Please upload the attached revised plans and documents onto Ocella for discharge of condition application **BN/30/20/DOC** at Angels Nursery, Yapton Road, Barnham.

Please see the email below which is the latest consultation response from **ADC Drainage Engineers** to **BN/30/20/DOC** – Angels Nursery, Yapton Road, Barnham.

Thank you for sending the revised details over. I have reviewed the majority of points and included comments below. I have not completed a detailed review of calculations to date as I am awaiting further details, e.g. impermeable areas plan, to facilitate a review of these. I have emailed the engineer directly requesting this further information.

DRAWING No. 19812-GS-Z1-XX-DR-C-5102

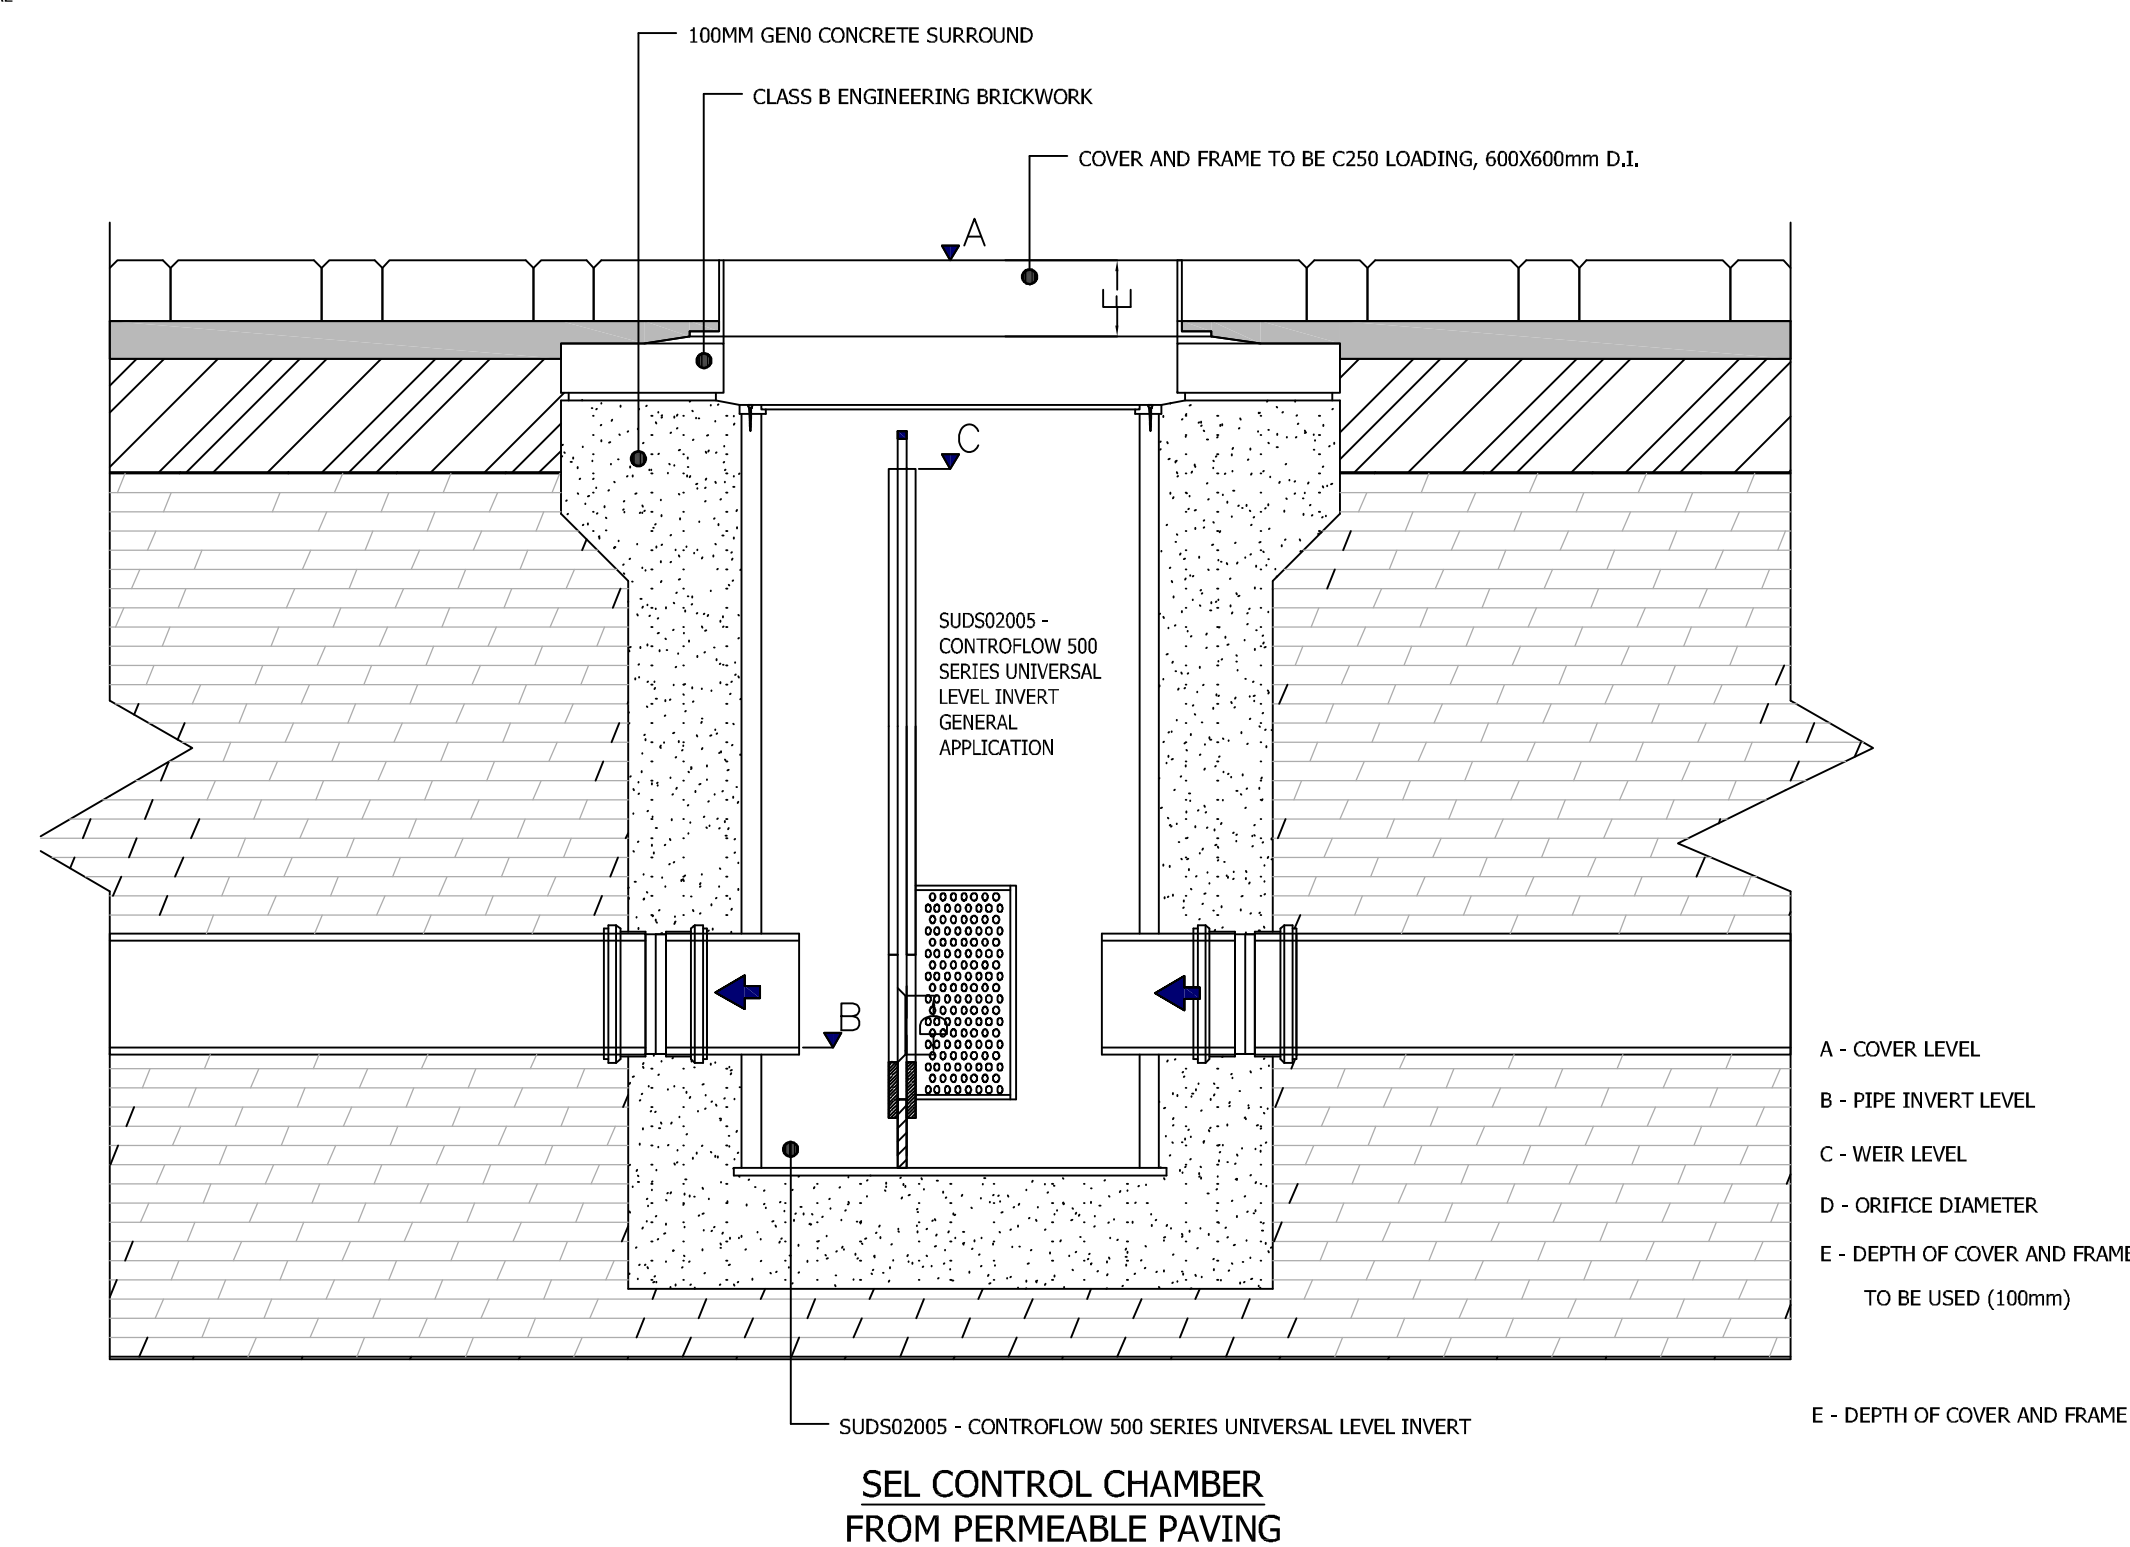
54. SMH control manhole on pond outlet – overflow pipe shown on plan? *Overflow not shown on detail. Please provide site specific detail. Revised on drawing 5102. Please indicate levels on*

construction detail drawing, including level of overflow. Please also provide a table of weir crest heights for flow controls from permeable paving.

**DISTRIBUTION/COLLECTOR TANK DETAIL WITHIN
TANKED PERMEABLE PAVING (MARKED DT ON LAYOUT)**

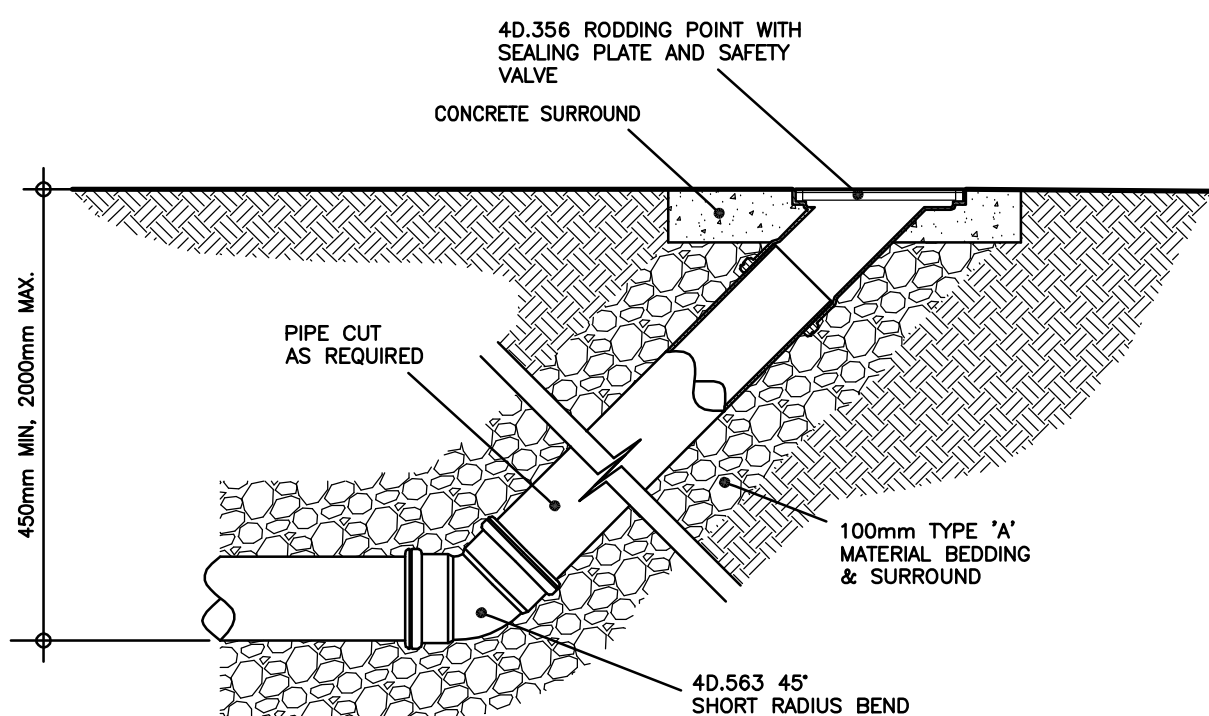
73. Provide construction detail distribution tanks on permeable paving outlets. *Please make it clear that invert level of outlet tanks is at formation level.* Note added to DT detail on drg S101.
